KITTITAS COUNTY COMMUNITY DEVELOPMENT SERVICES

RE: Forgey Short Plat Final (SPF-26-00002) – Staff Review and Request for Final Mylars

FORGEY SHORT PLAT
PART OF SECTION 23, T. 17 N., R. 19 E., W.M.
KITTITAS COUNTY, WASHINGTON

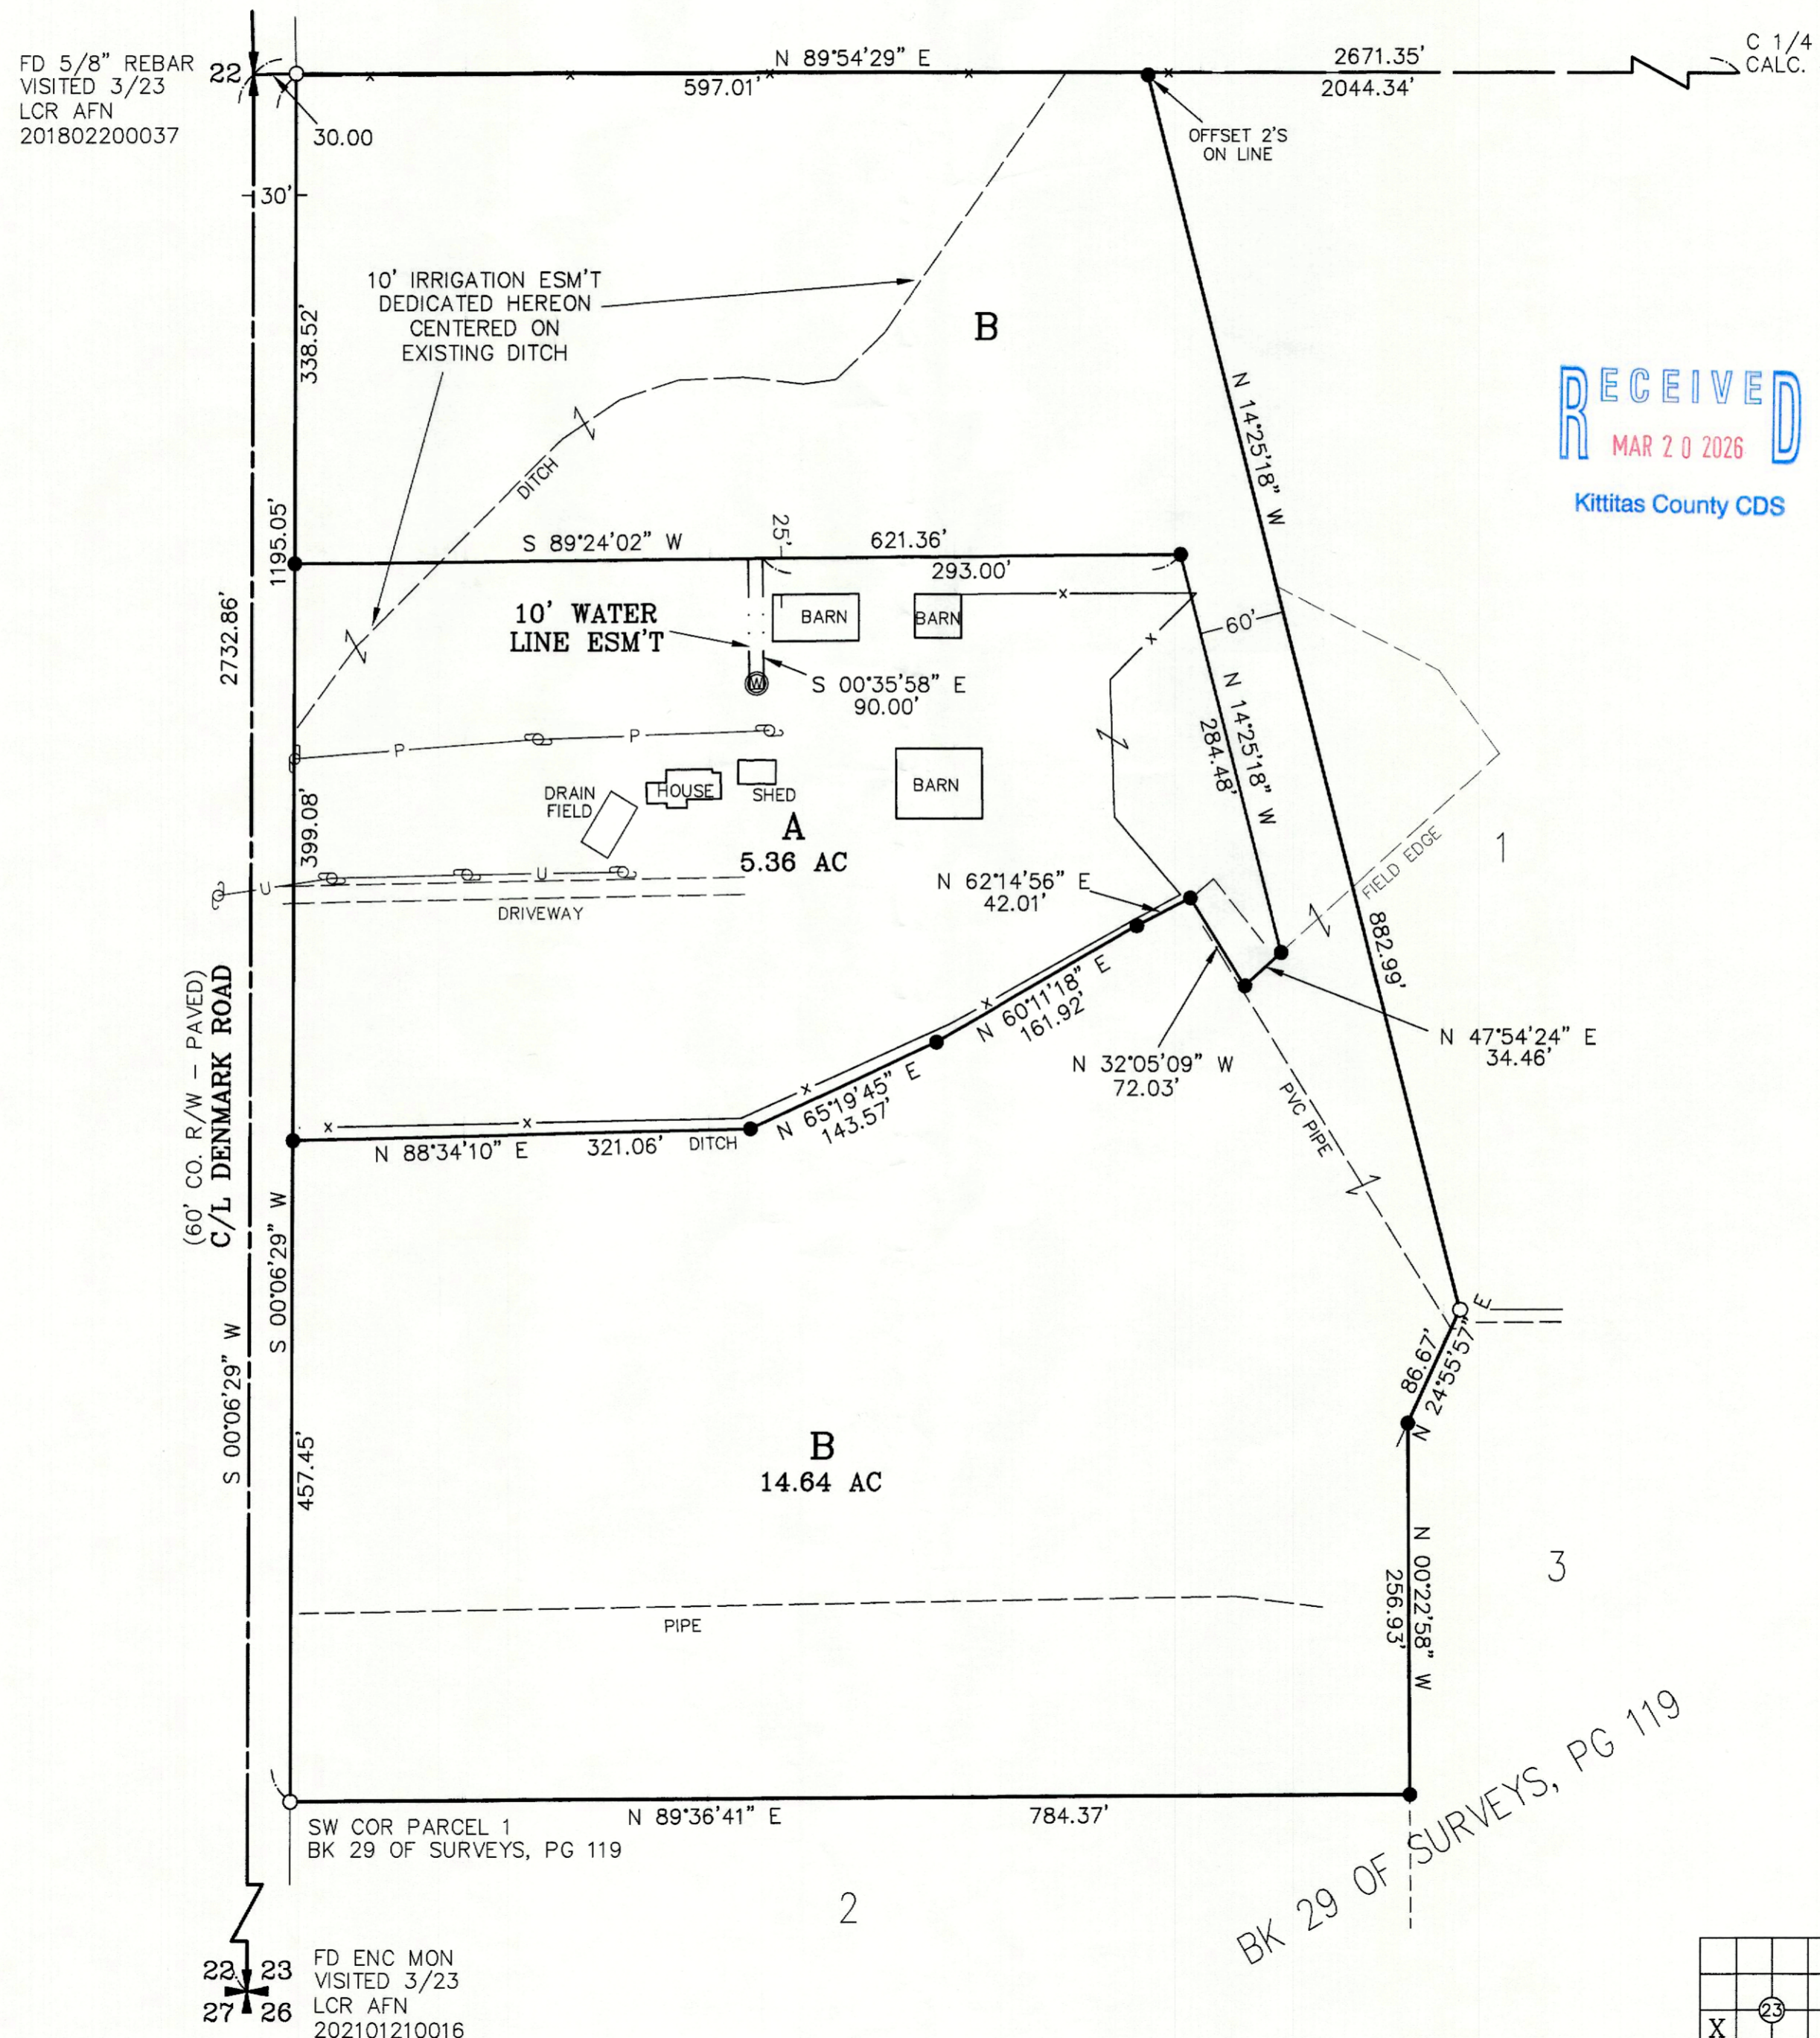
- "SPF-26-00002 Forgey" must appear on the face of each mylar sheet along with the Preliminary Short Plat project number "SP-22-00006 Forgey".
- A Signature Box for the irrigation entity "Ellensburg Water Co." must be added to the face of the mylar and must be signed and dated by a representative of Ellensburg Water Co. prior to submittal to our offices.
